Gatwick Airport Northern Runway Project

The Applicant's Response to Actions
ISH 8: Draft Development Consent Order

Application Document Ref: 10.50.6

PINS Reference Number: TR020005

DAYLIGHTED CHANNEL EXTENSION OF RIVER MOLE

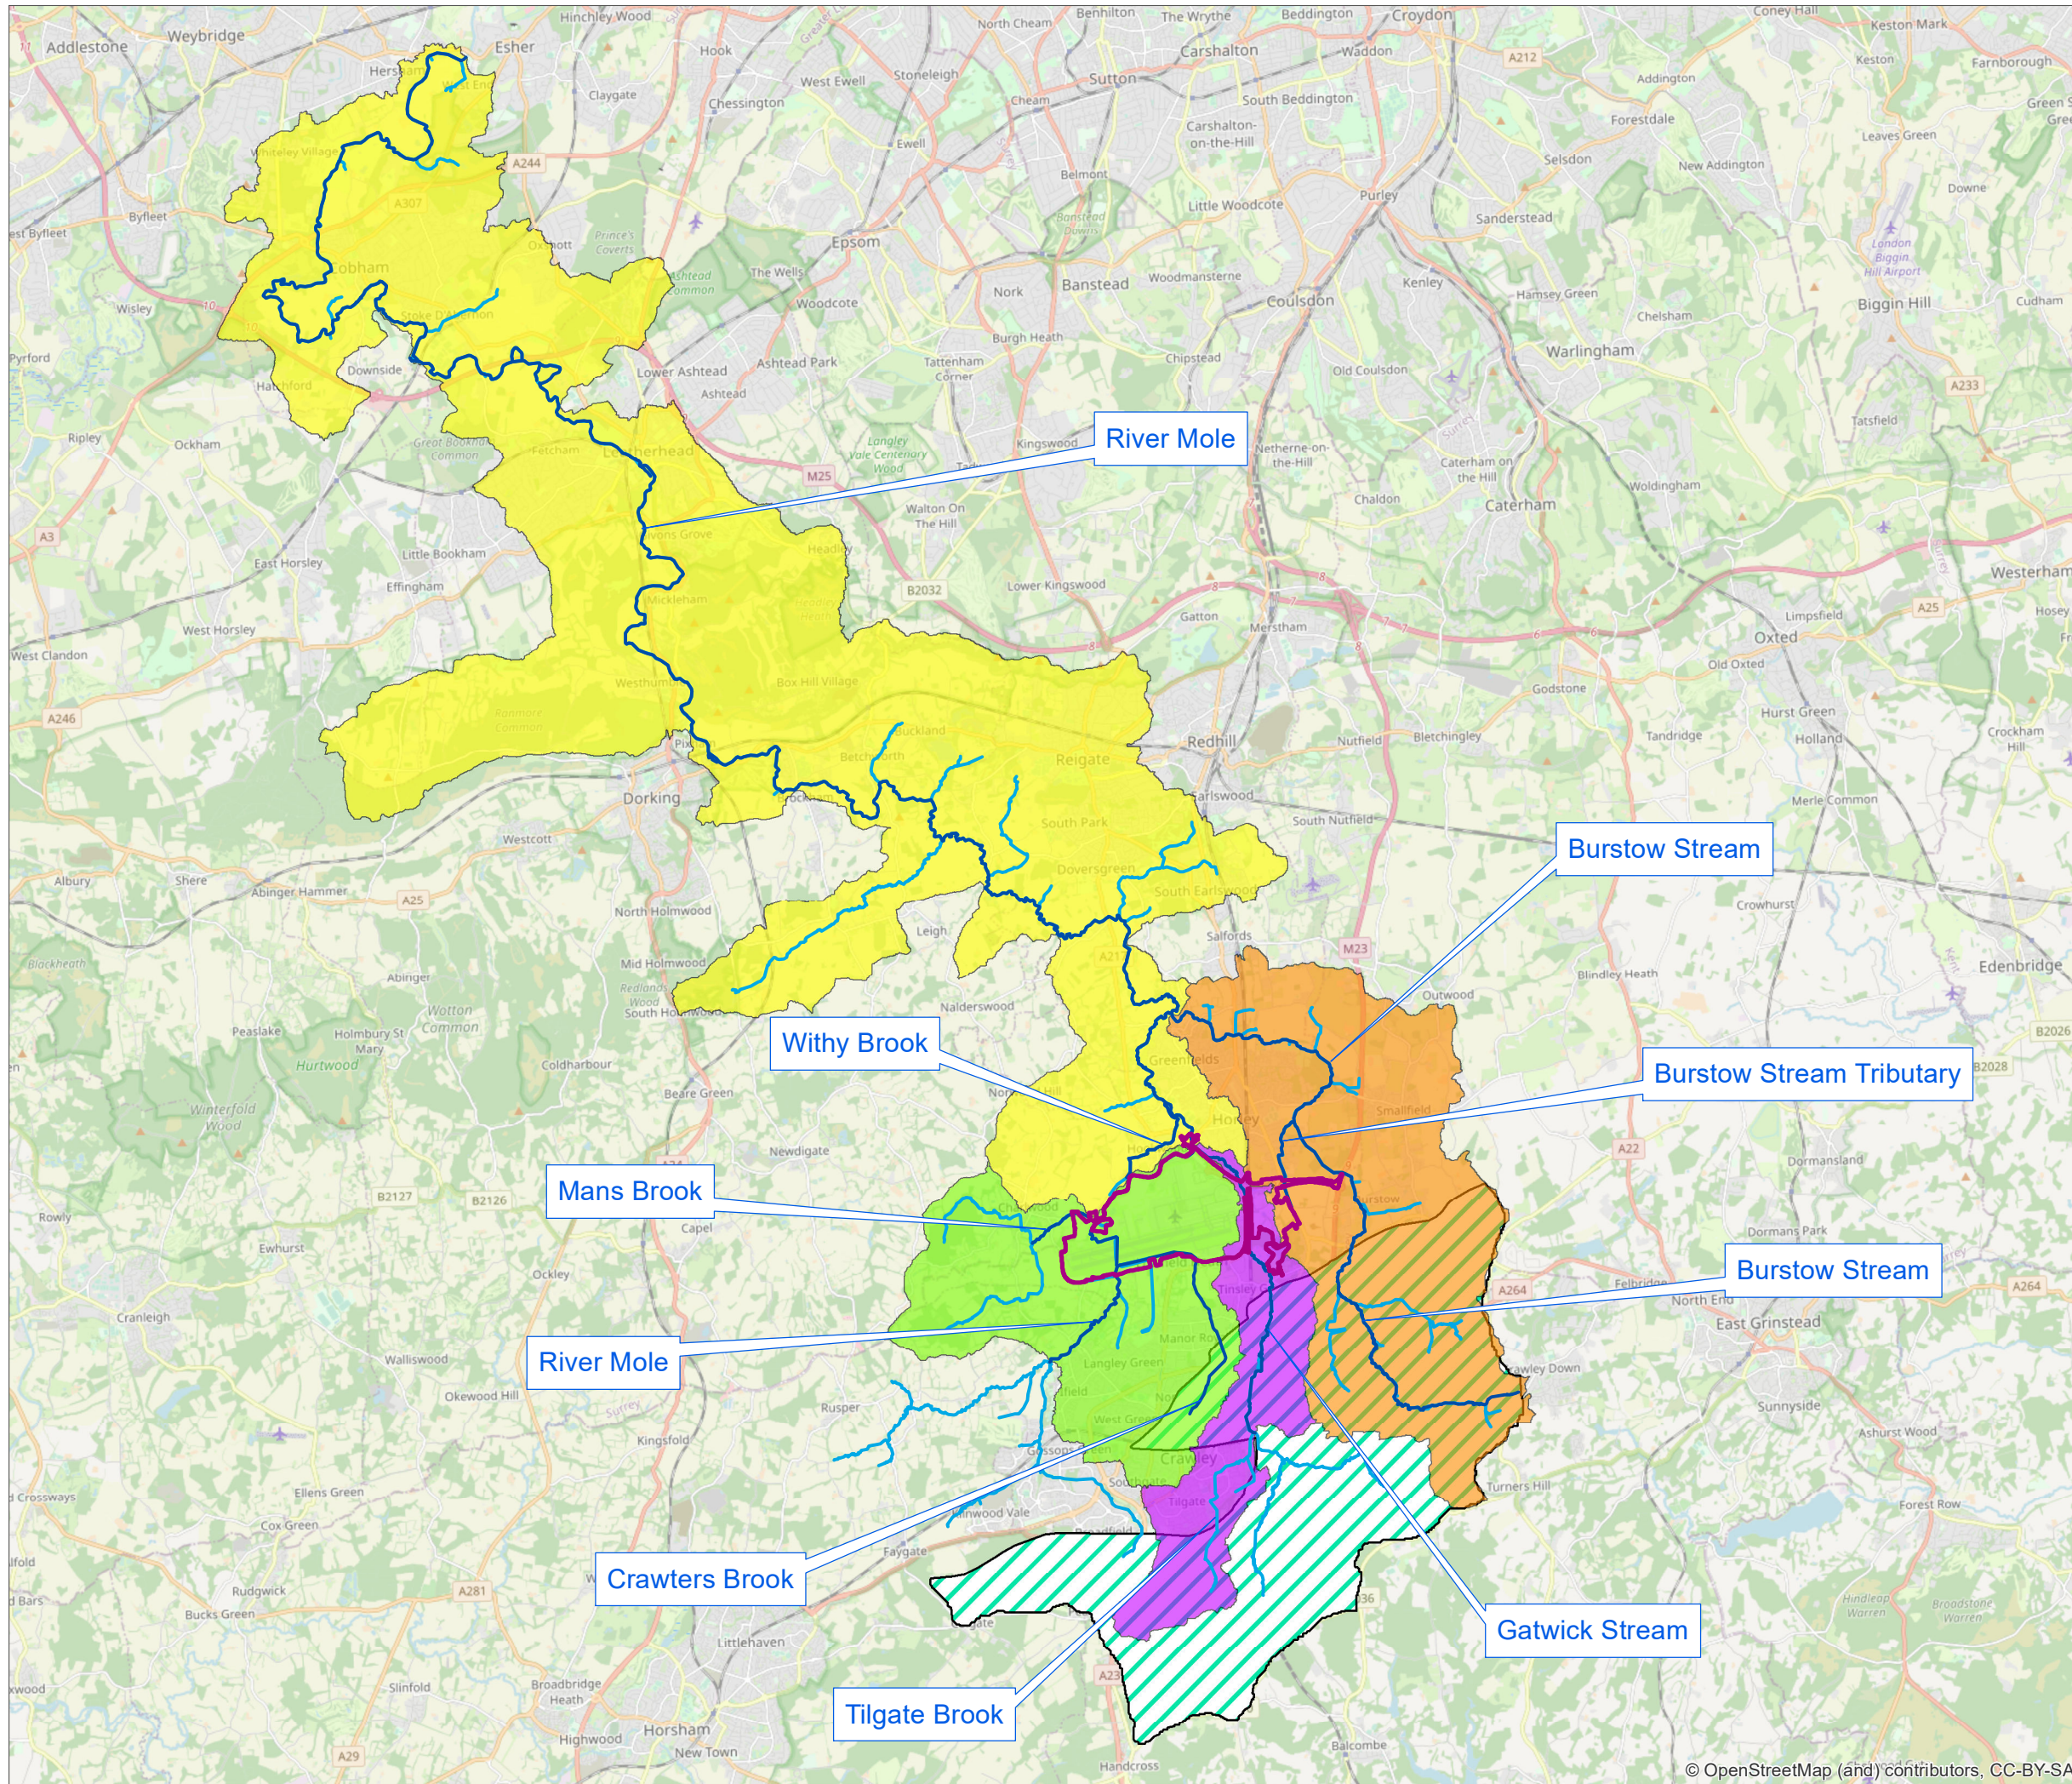
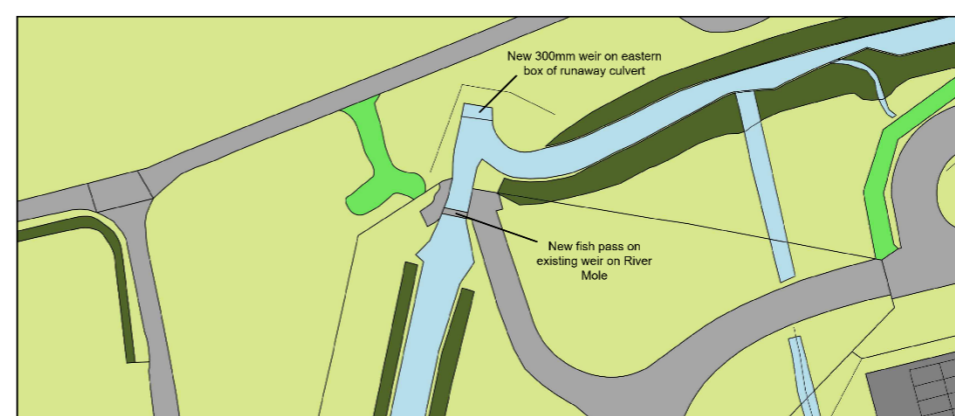
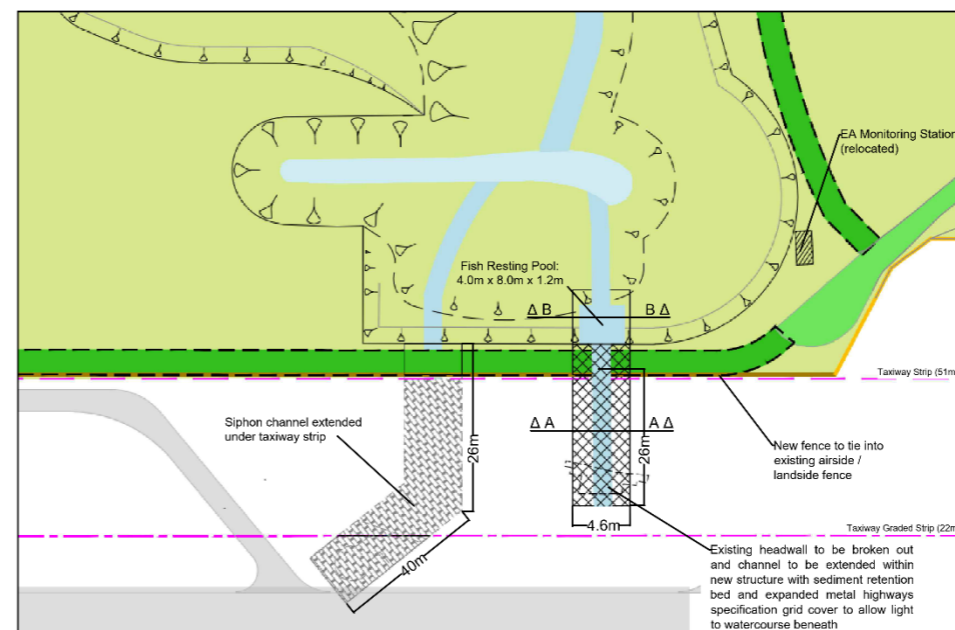
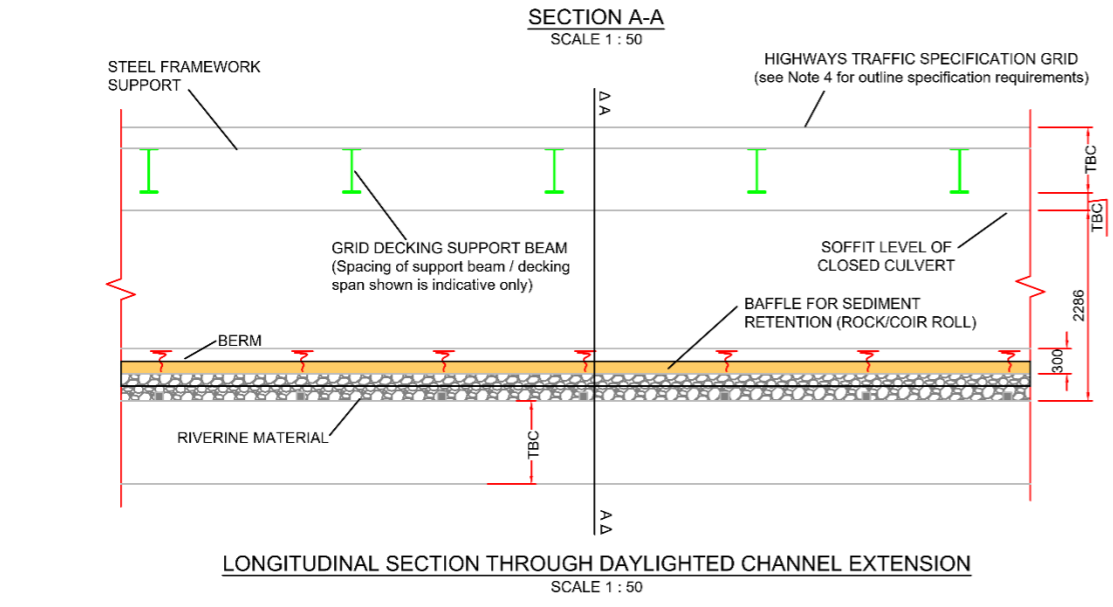
- 3.1.3 In relation to the JLAs' specific comment on Work No. 39 (works associated with the River Mole), the Applicant adds the following by way of additional explanation:

- 3.1.4 The repositioning of the northern runway 12 metres northwards and the resulting necessary revisions to the airfield layout (such as changes to Taxiway Juliet) require the infilling of Pond A and the extension of the existing culvert and syphon that convey the watercourse beneath both runways. The extended channel is covered to prevent vehicles from entering it and includes riparian planting, and at its outlet a fish resting pool to facilitate fish movement through the structure.

- 3.1.5 The River Mole will be realigned and renaturalised downstream of the runway culvert. This would improve channel sinuosity and variations in the channel form and features would improve natural geomorphological processes, allowing the channel to act more naturally. The features will include areas of gravels to speed up flow and areas of deeper pools to provide slower water, generating variable depths and water speeds and therefore changes to sediment transport and the size of sediment deposited/transported. As a result there will be reduced likelihood of over-siltation and stagnation of the river system. The other additional benefit is that these features improve the overall aquatic environment both in-channel and along the margins by providing natural bed sediment in-channel for invertebrates and fish, whilst marginal features create lots of areas for invertebrates, fish resting refuges and macrophytic plant life. Combined, these
